From: [chris helgeson](#)
To: [Rachael Stevie \(CD\)](#)
Subject: Sparks Park SE-18-00008/SE-20-00008?
Date: Saturday, August 14, 2021 11:32:25 AM

The application number noted in the letter you sent to KCFD3 does not exist, in doing some digging I found it as SE-18-00008 not SE-20-00008 as it was noted. The only comments I have regarding the building of a road are;

**SPARKS ROAD**  
 NATHAN WEIS  
 EXISTING CONDITIONS & CLEARING AND TESC PLAN

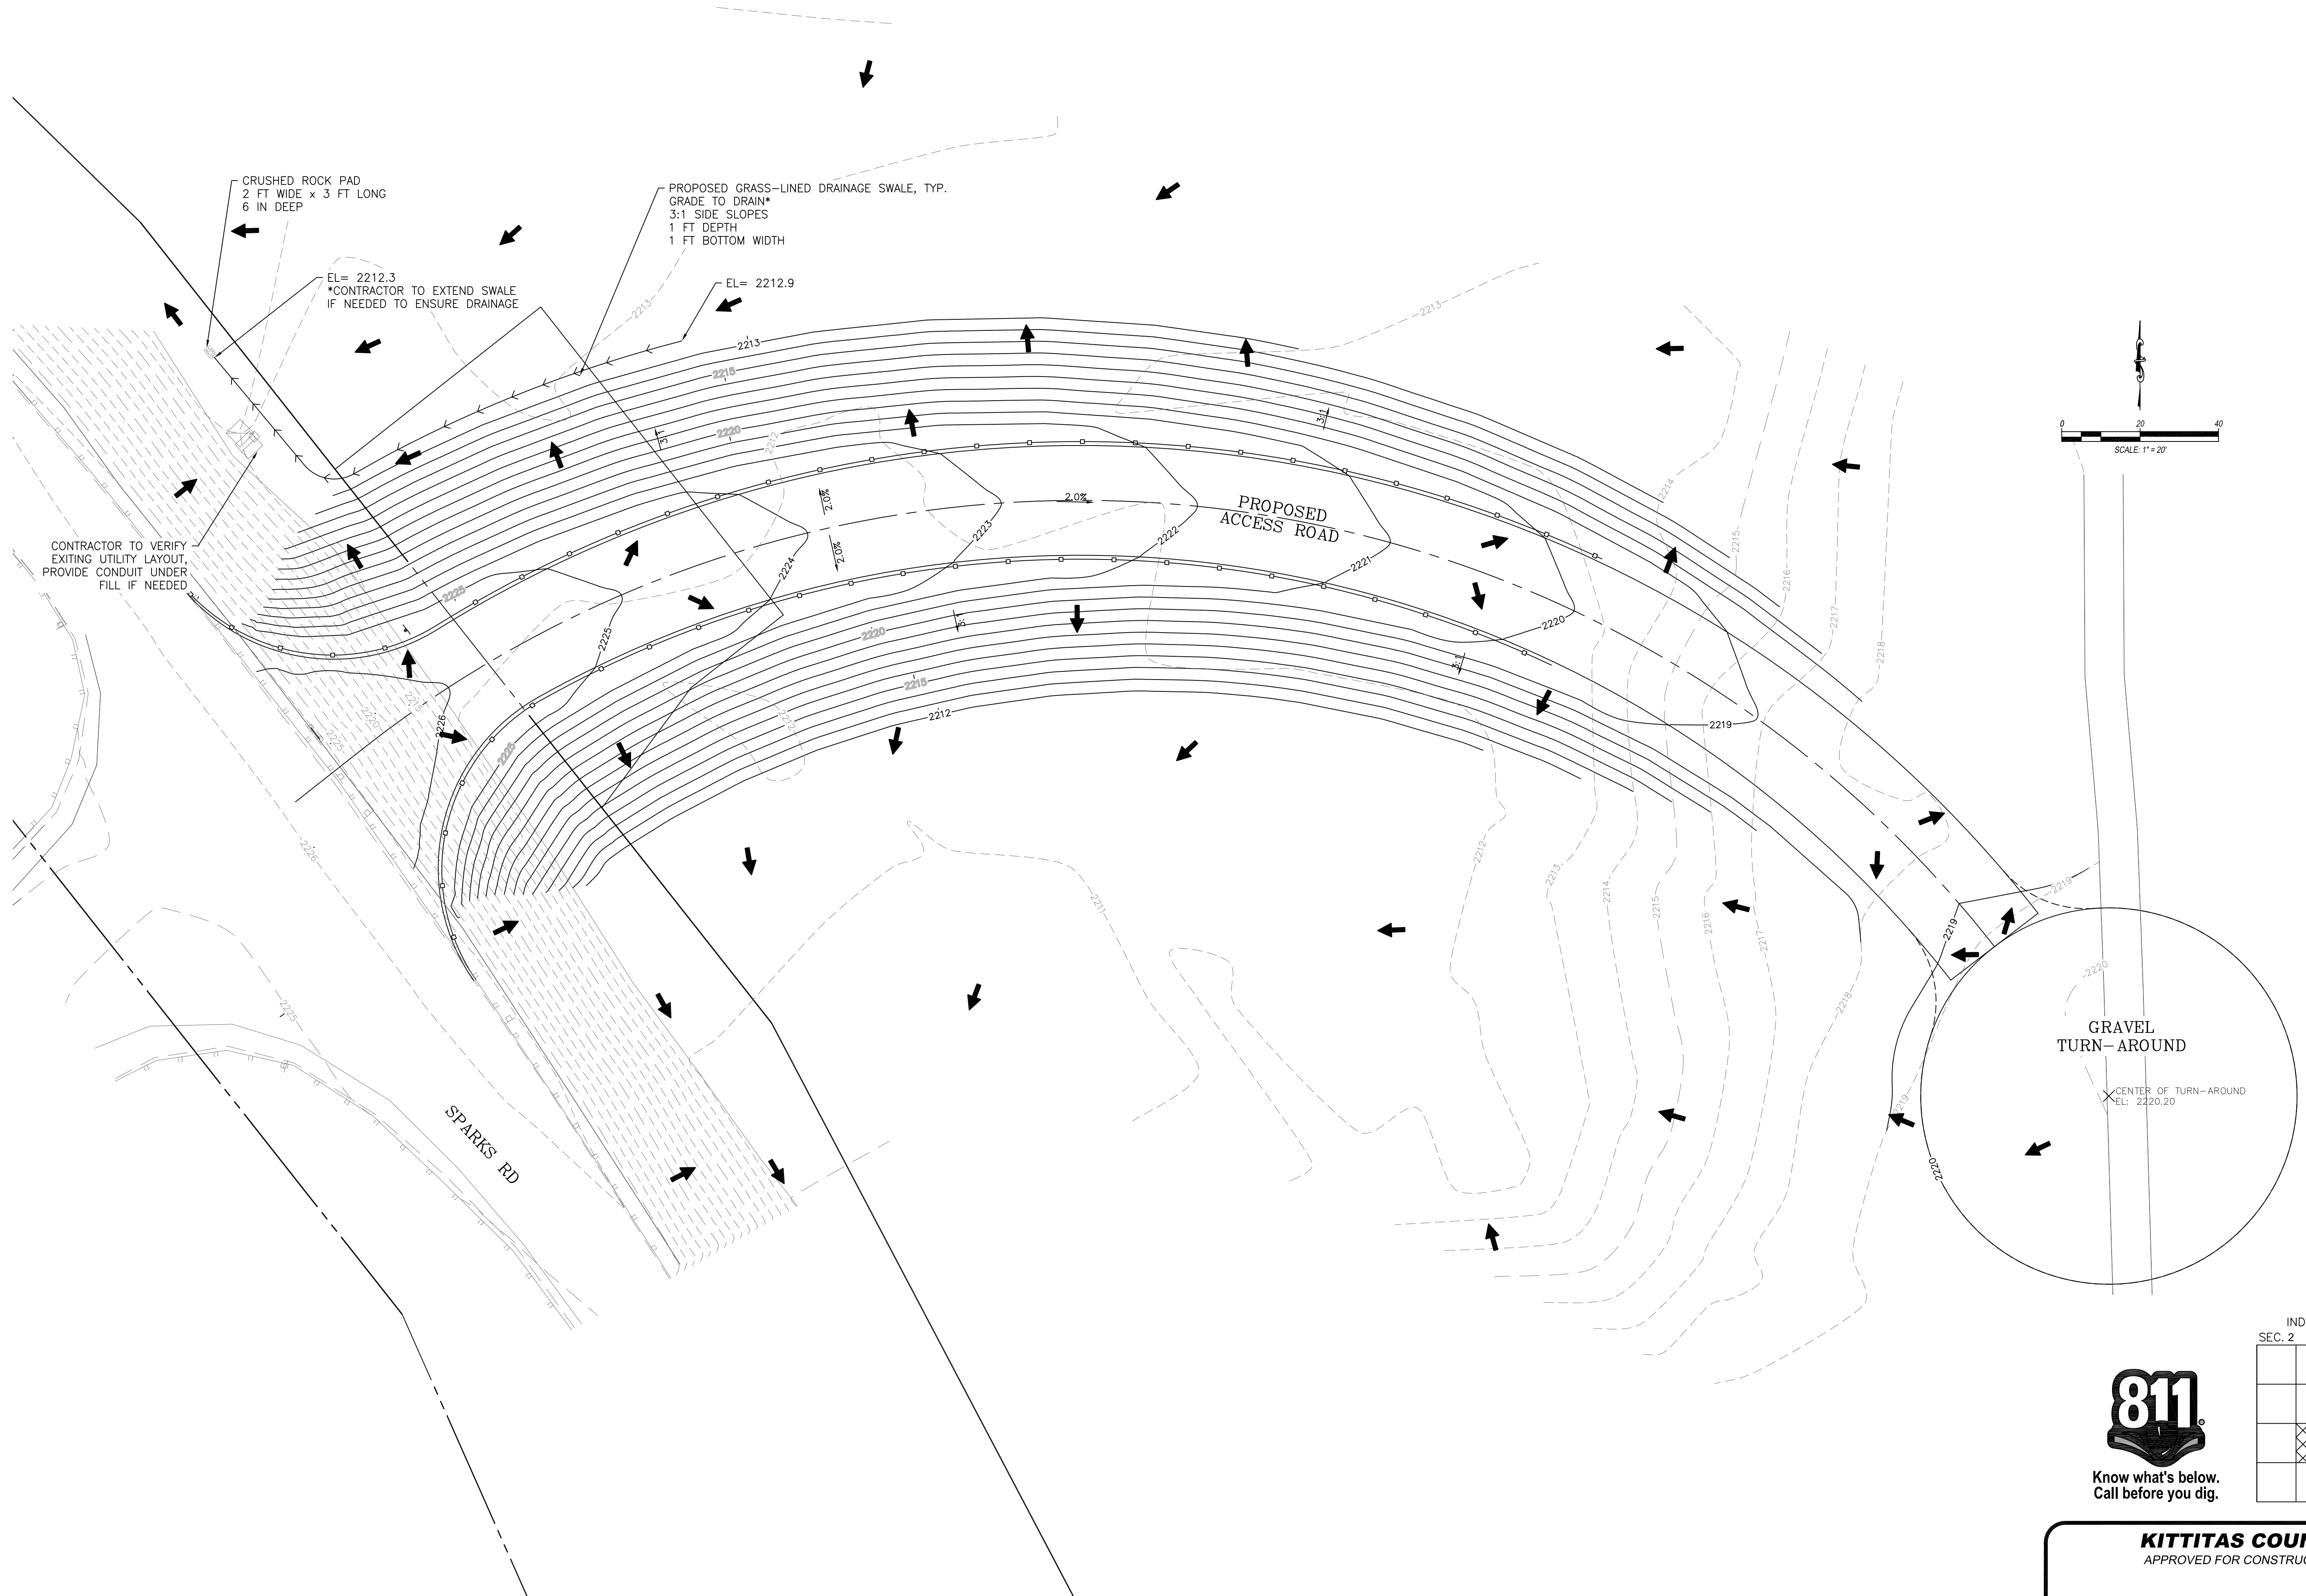
Currently there are large piles of slash and felled timber on the property that is very dry and a fire risk, what are the plans to mitigate this from happening again (hauling away, chipping)?

**SPARKS ROAD**  
 NATHAN WEIS  
 ROAD PLAN AND PROFILE

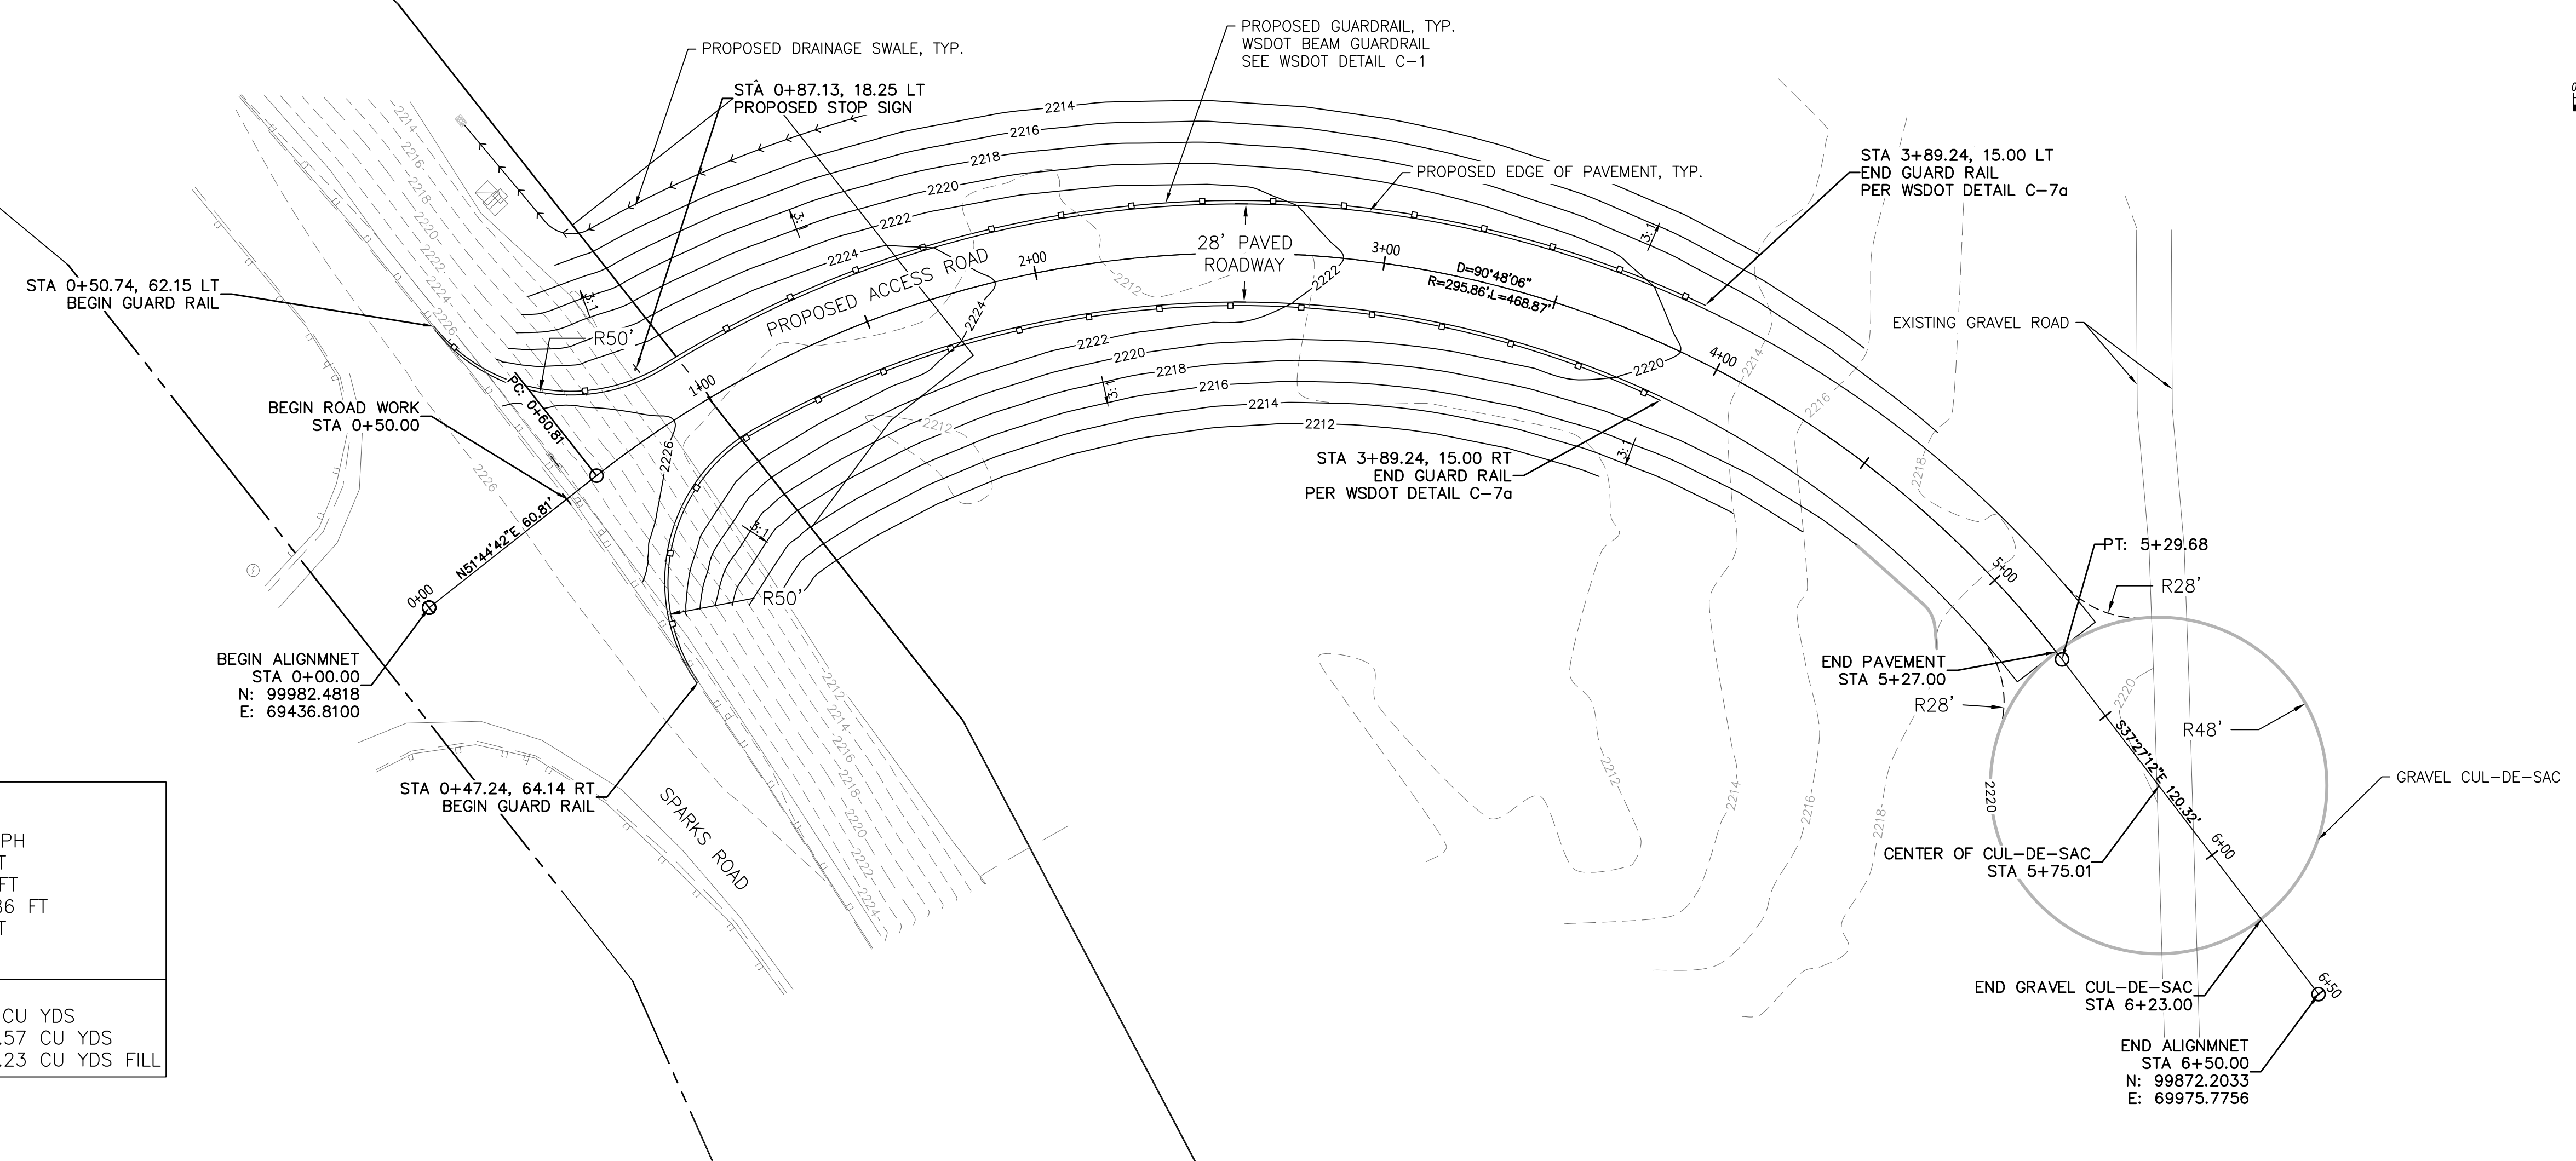
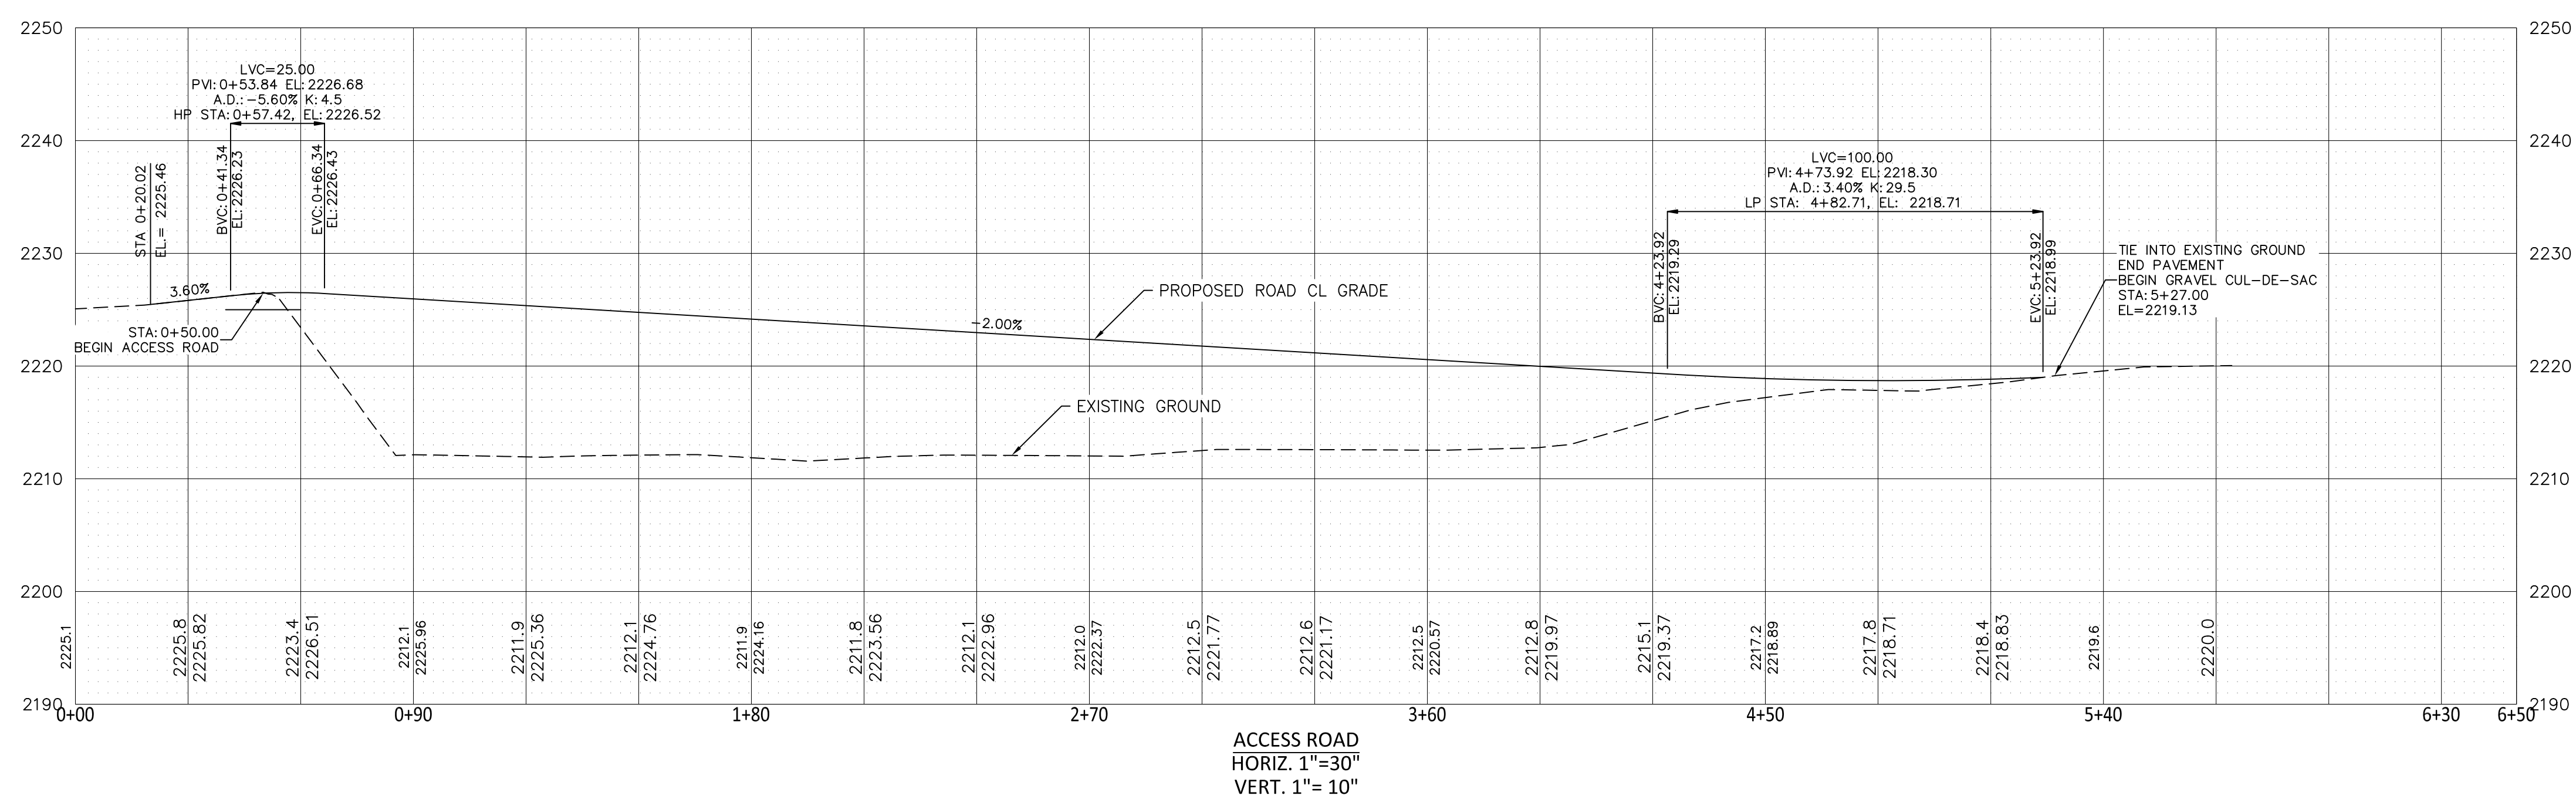
Proper turn arounds and ingress/egress as required by law for Fire/EMS services. Minimum cul de sac size is 96' for a fire engine to be able to properly turn around.

Will there be hydrants added on proposed road for future development?
